Your ref: 3/2017/0270

Date: 3rd April 2017

Planning Applications 3/2017/0270: Creation of new vehicular and pedestrian access and area of additional car parking associated with the adjacent Holmes Mill development; 62 Moor Lane Clitheroe BB7 1AJ

drg.no. 14/59 SK10 rev. A

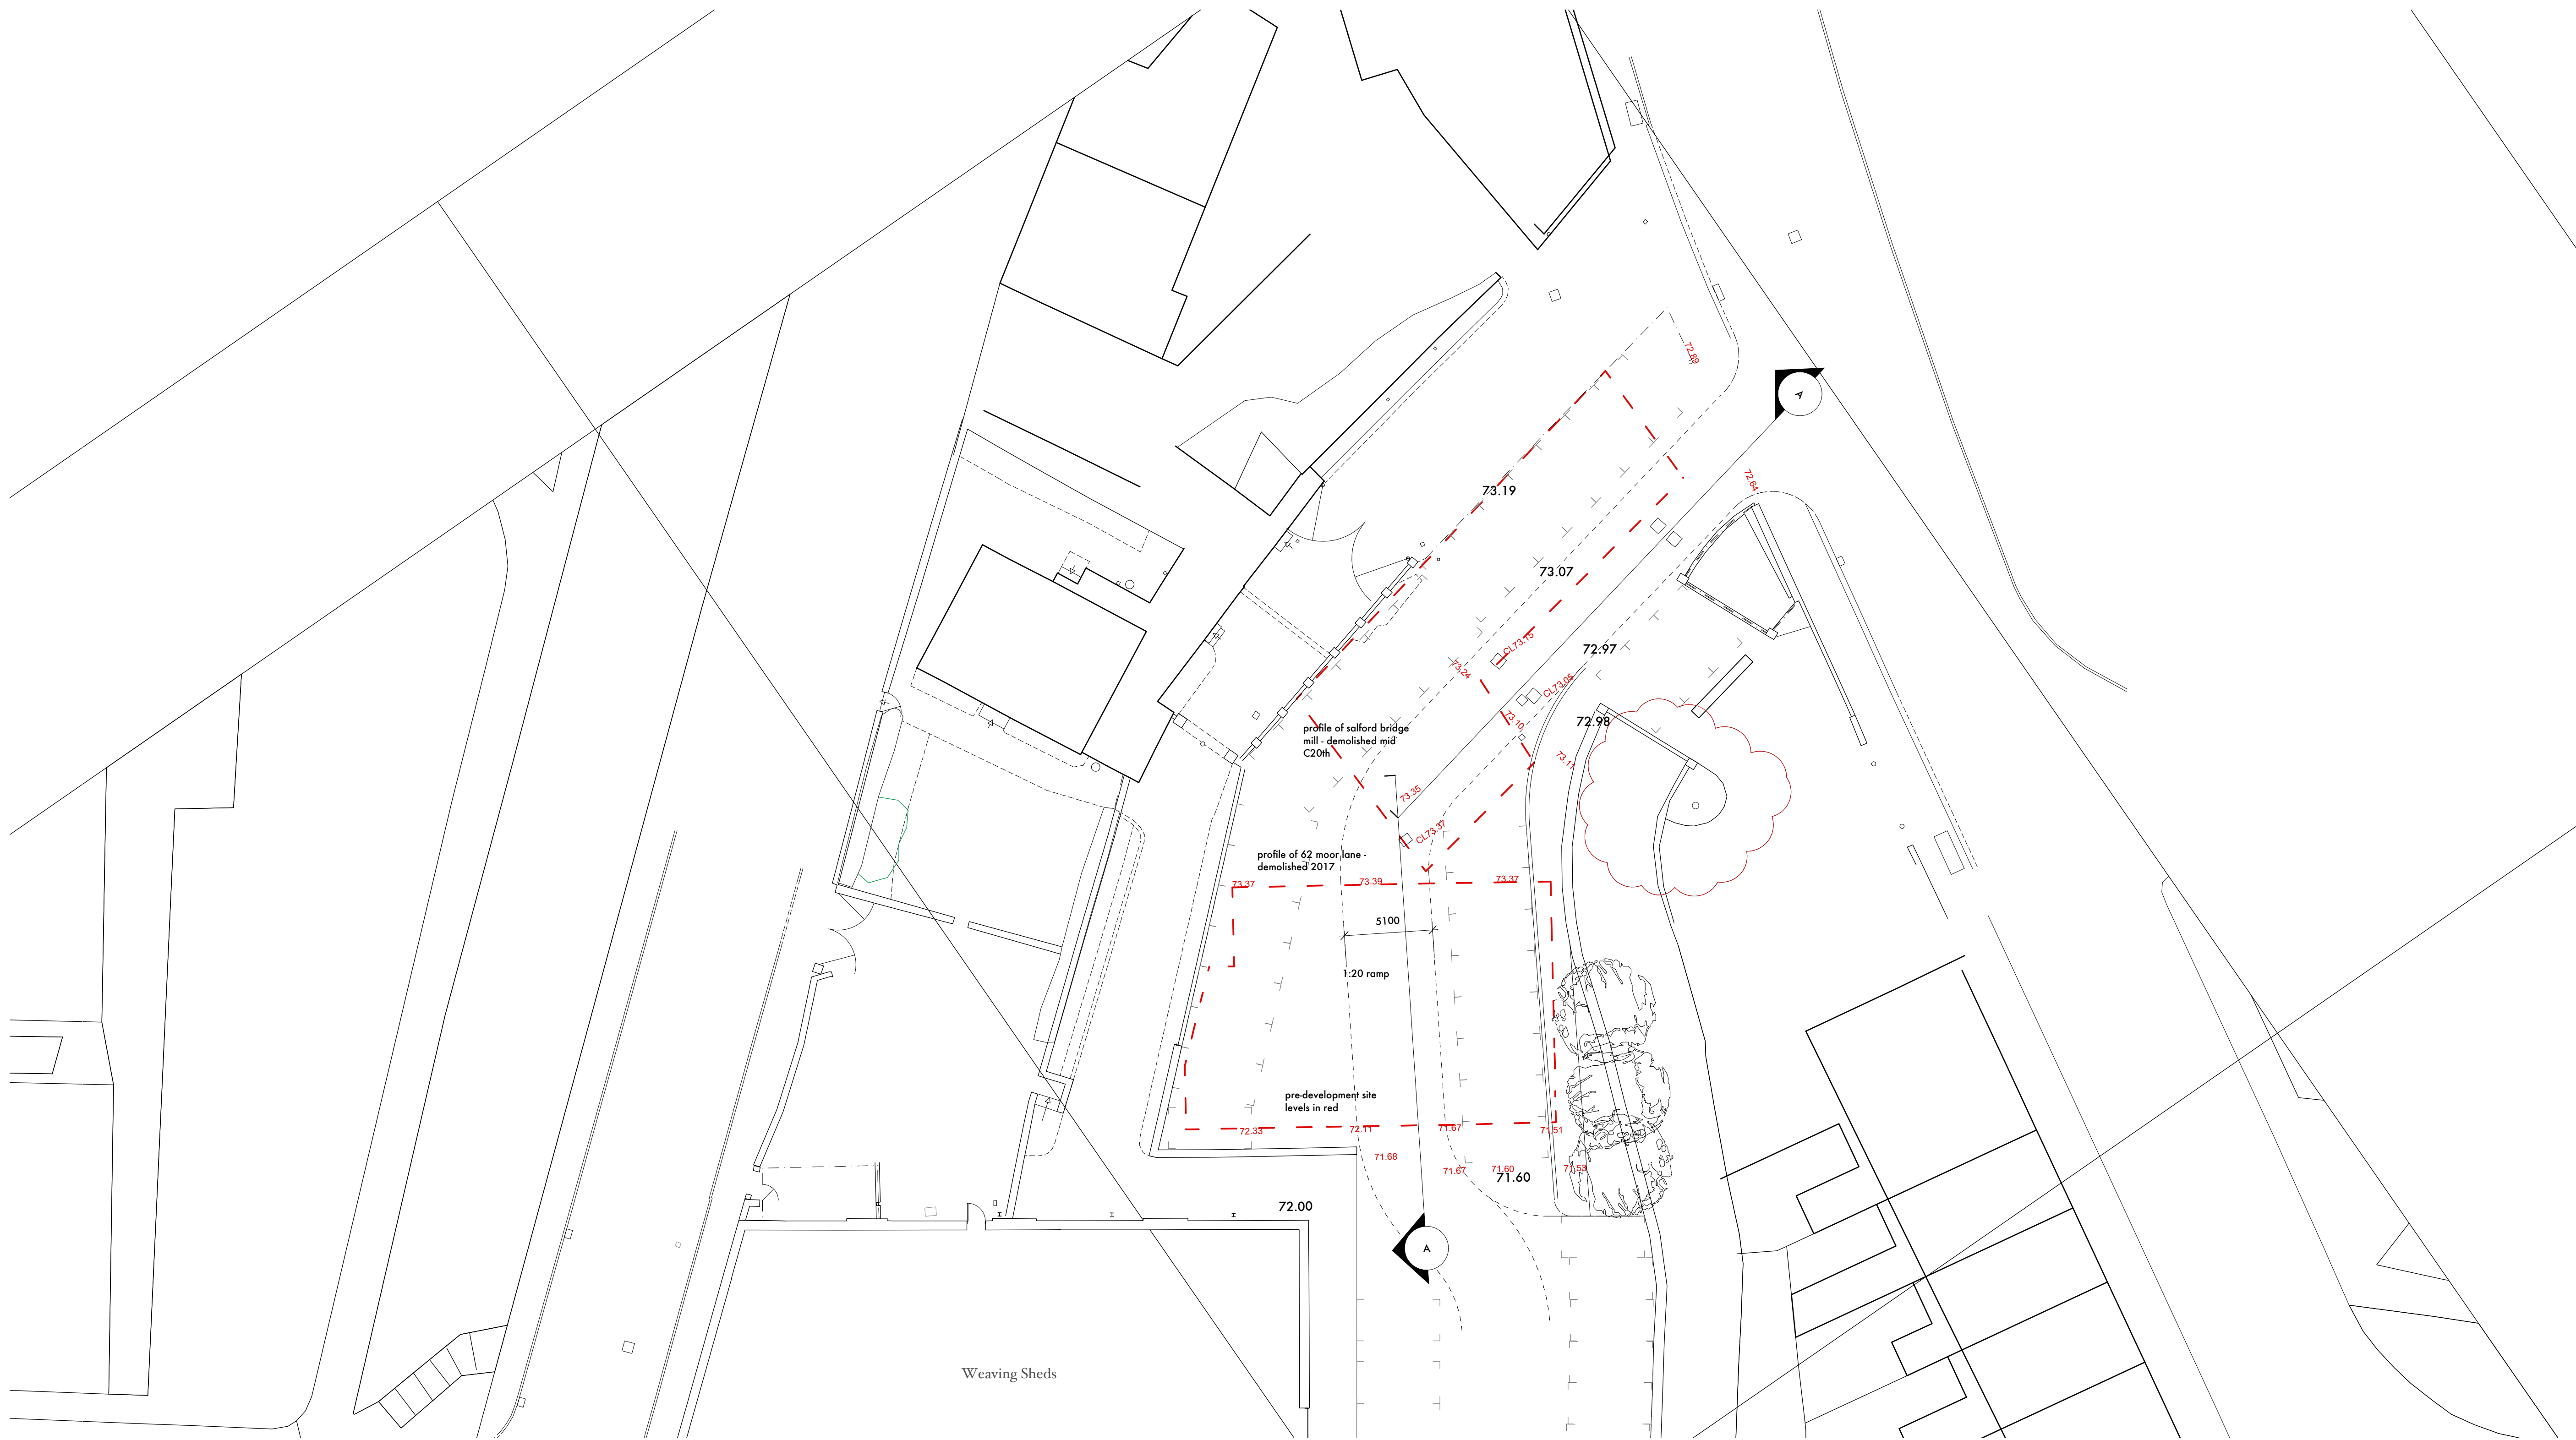
However the proposals appear to require the cutting away of the ground beneath the building to form a ramp down to the Holmes Mill yard. This detail is rather unclear on the drawings, with no levels being shown on the Proposed Site Plan and no representative section(s) being provided. The only place where a ramp is mentioned in any detail is the Construction Method Statement, where a hatched rectangle is drawn on the plan provided on Page 6 (Stanton Andrews Plan14/59 D1 Rev A, Jan 2017). This area is dimensioned to be 7m wide and slightly longer than the present building footprint. It is annotated: '*Concrete slab, footing and masonry to be removed to allow for a ramped access. 1.7m change in level over 18m...*' giving a *circa* 1 in 10 slope.

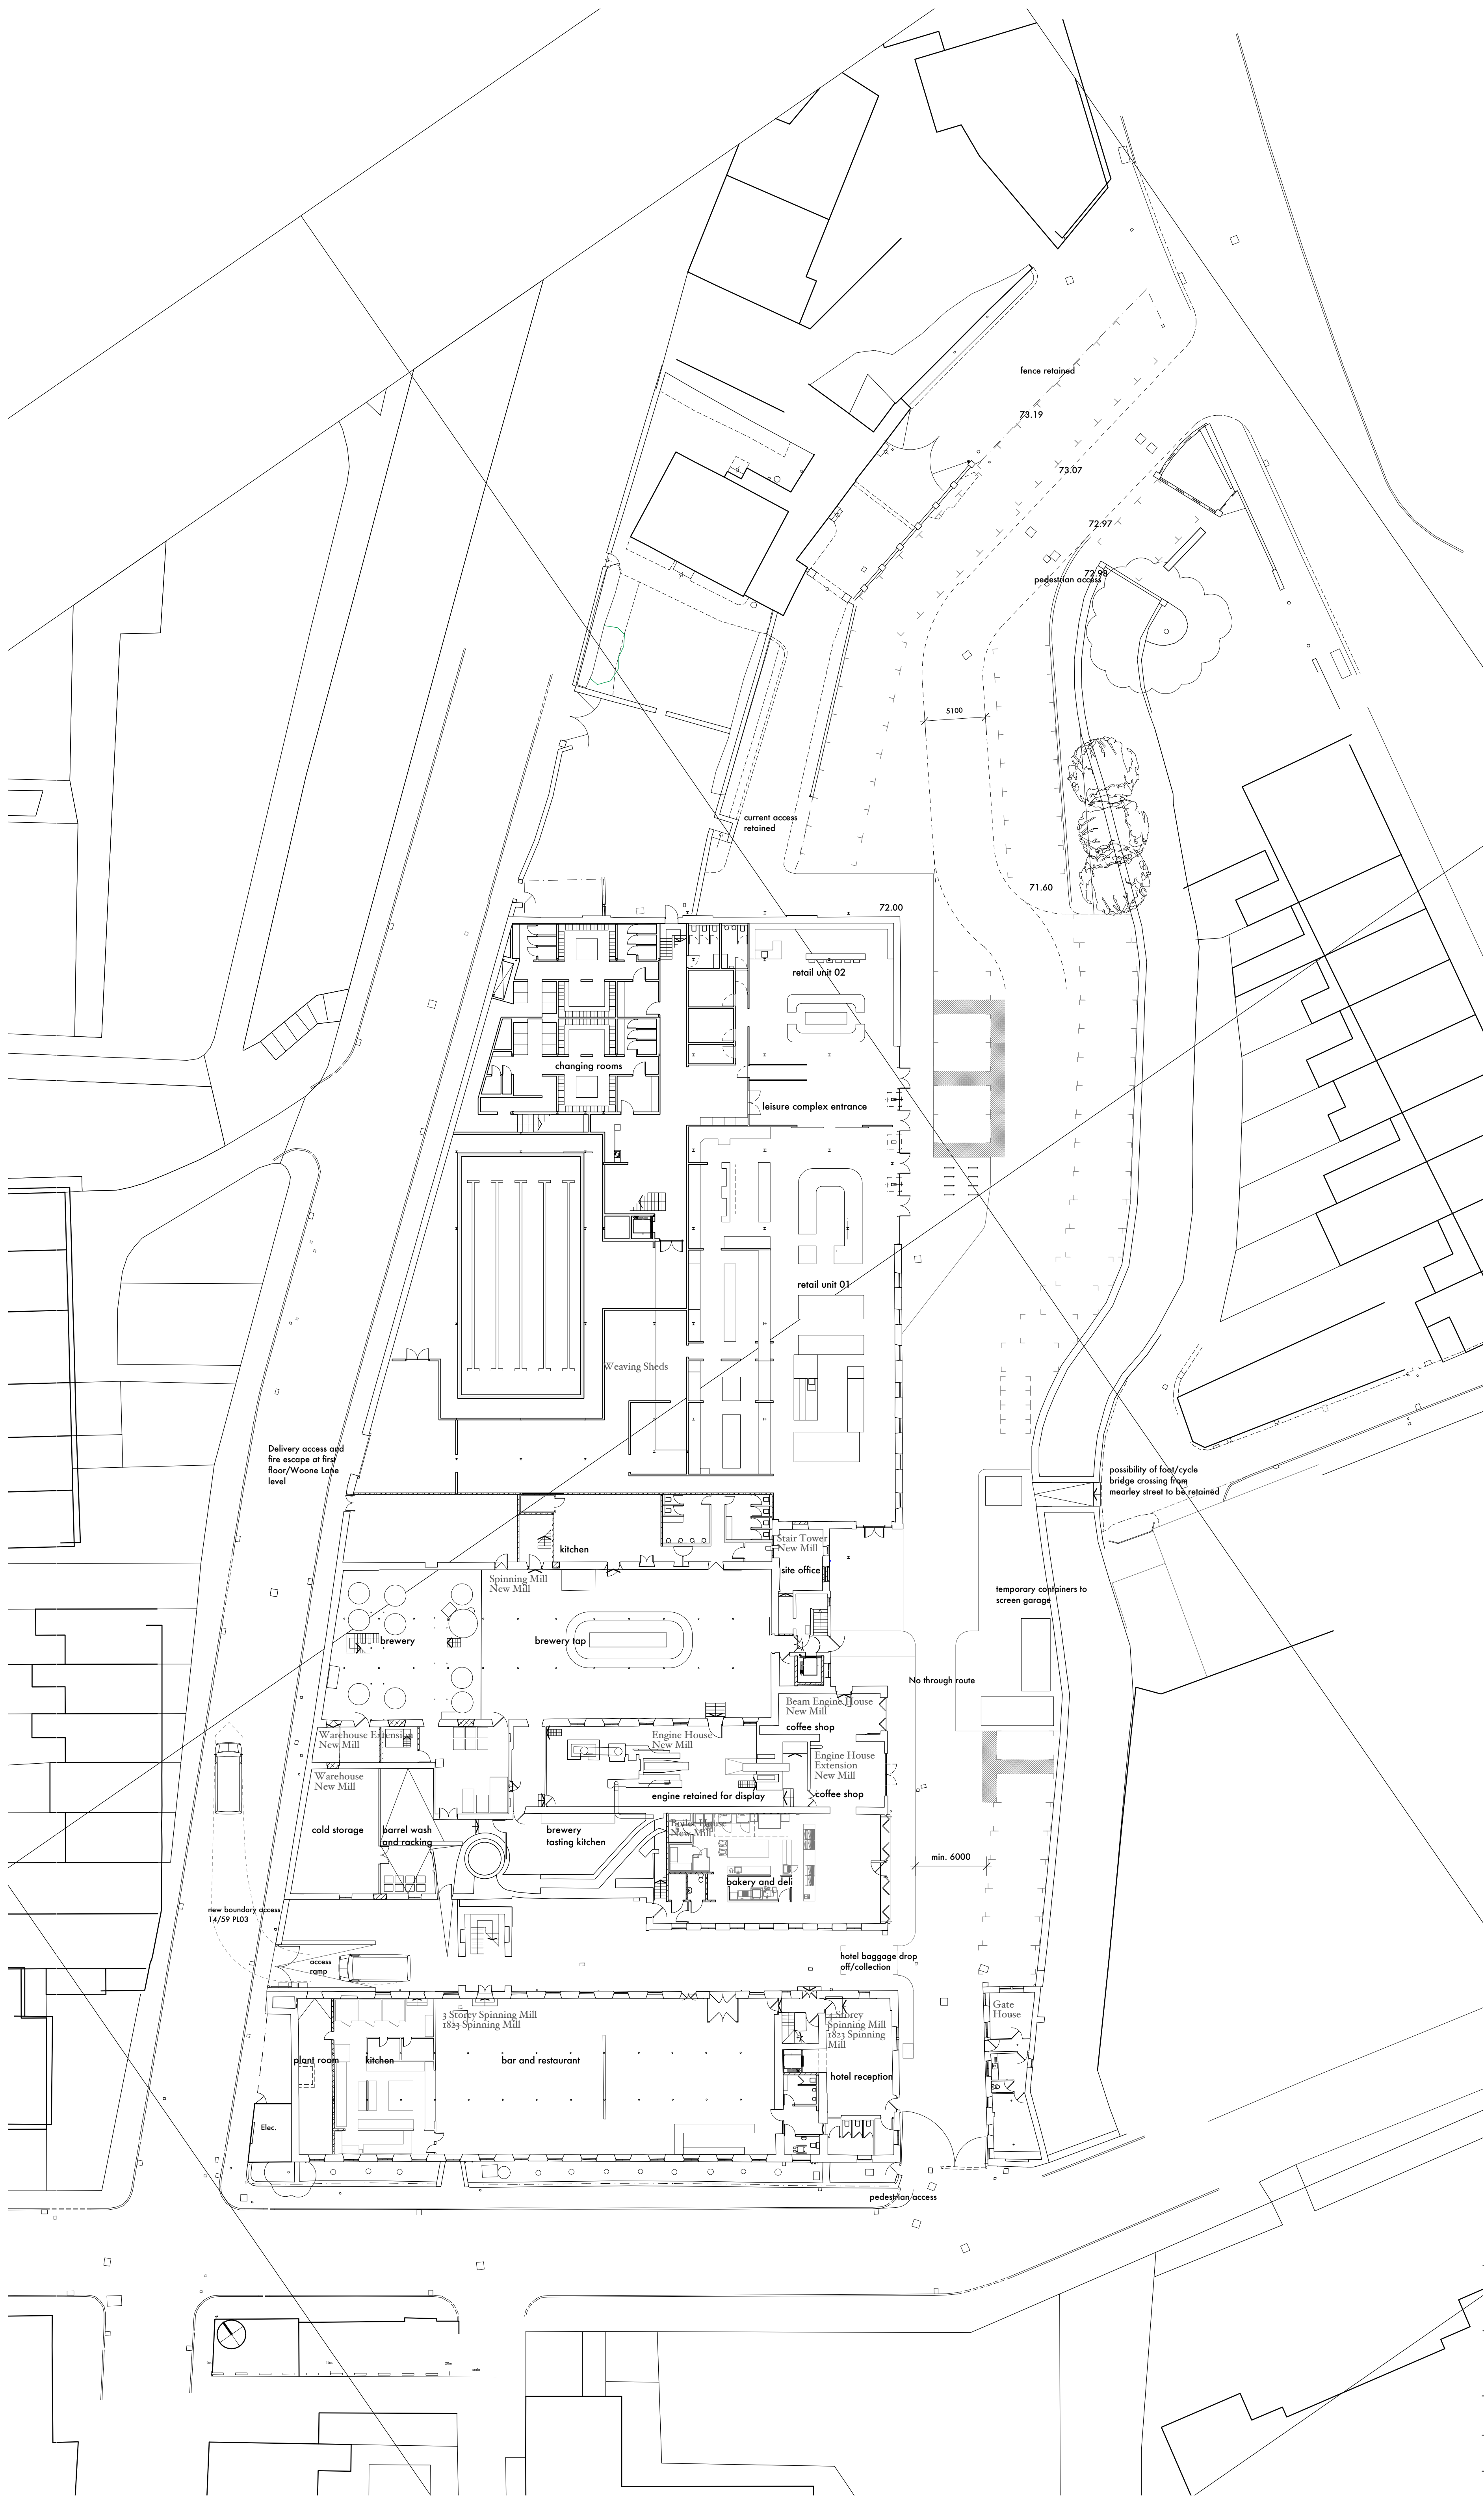
No safety fences are shown either side of this ramp on the Proposed Site Plan and the arrangement of parking spaces would not allow for them in any case, so it must be presumed that the whole southwest end of the site is intended to be reduced. The proposed 1 in 10 slope from the Construction Method Statement would appear rather steep for side-on parking as shown and thus it must be presumed that the site level reduction will also extend significantly further northeast. This will threaten the buried remains of the pre-1822 mill.

- (i) A full description and/or plan of the proposed parking area, including levels and sections;
- (ii) An assessment of the impact of the proposals on the buried remains of Salford Bridge Mill;
- (iii) A written scheme of impact mitigation (if required).
